**Planning Department
Transportation Development Services**

May 28, 2014

Re: White Diamond, 312 Florida St.
Submittal for Certificate of Occupancy – Transportation Development
Architect's Stamp dated 02-27-14 (K18-D105)
Certification dated 05-19-14

TCL PLAN

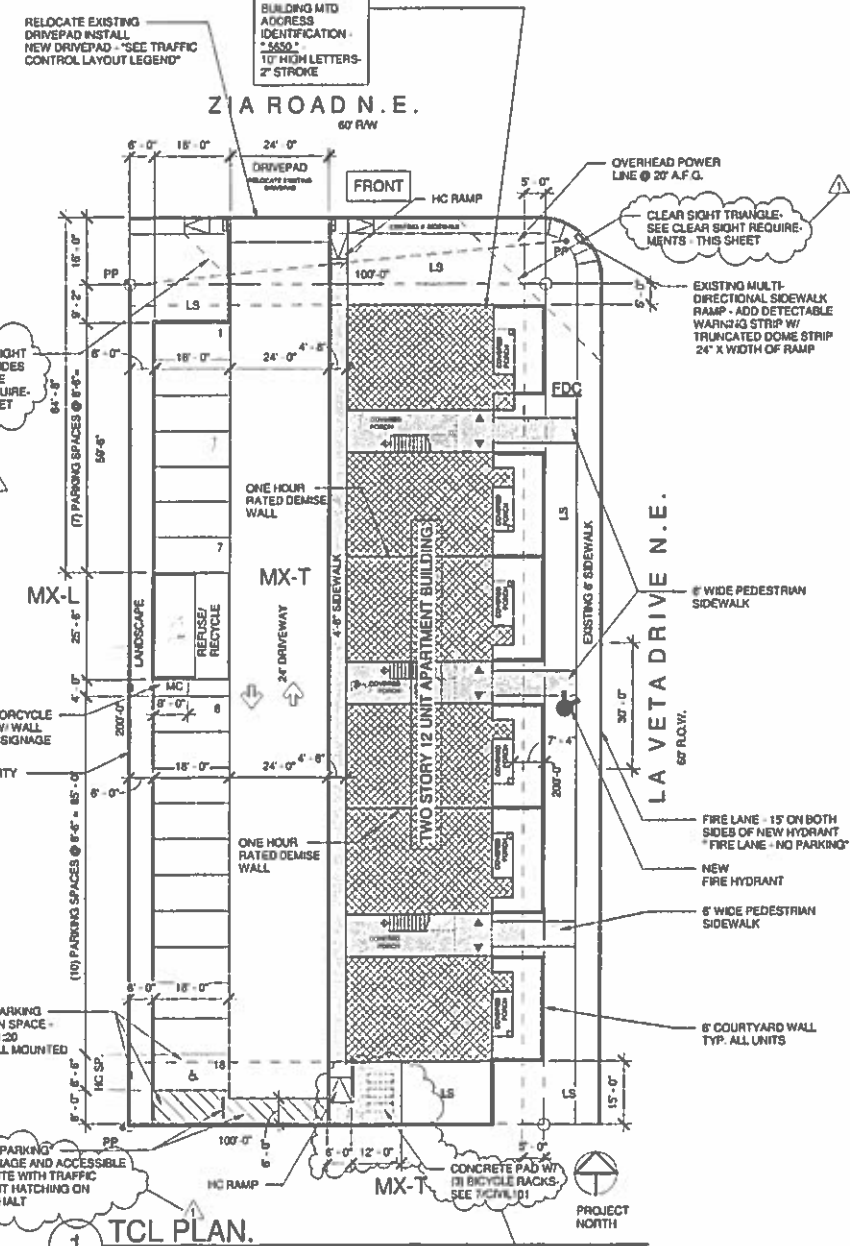
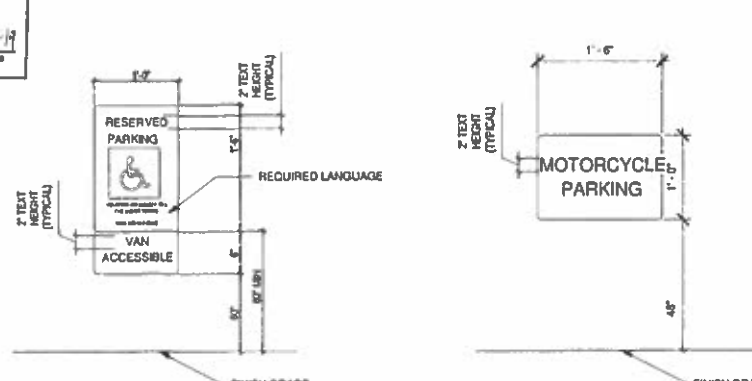
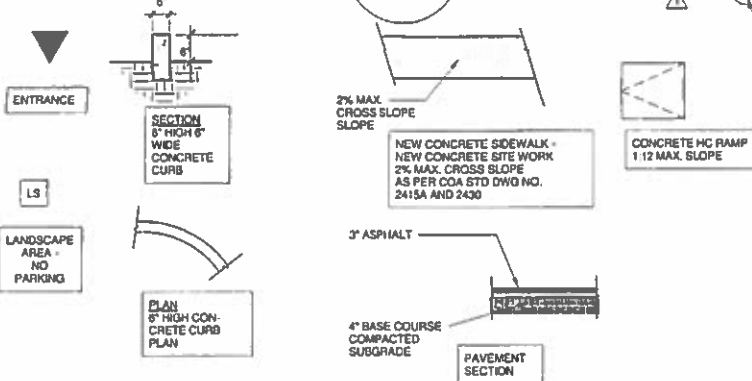
2. There is no way to access the proposed three parking spots located in the northeast corner of the site. Please provide clarification if the chain-link fence will be removed.

3. Unused curb cuts need to be replaced with standard curb, gutter and sidewalk.
4. A Wheelchair accessible parking space sign was affixed to the west side of the building. This is not an appropriate place for parking and as such it should be removed.

5. All parking bumpers shown on the plan should be installed.
6. "NO PARKING" should be painted in large letters on the wheelchair access aisles.
7. Please indicate on the plan where the main entrance is. Signs on the doors did not make it clear where the accessible route is located.
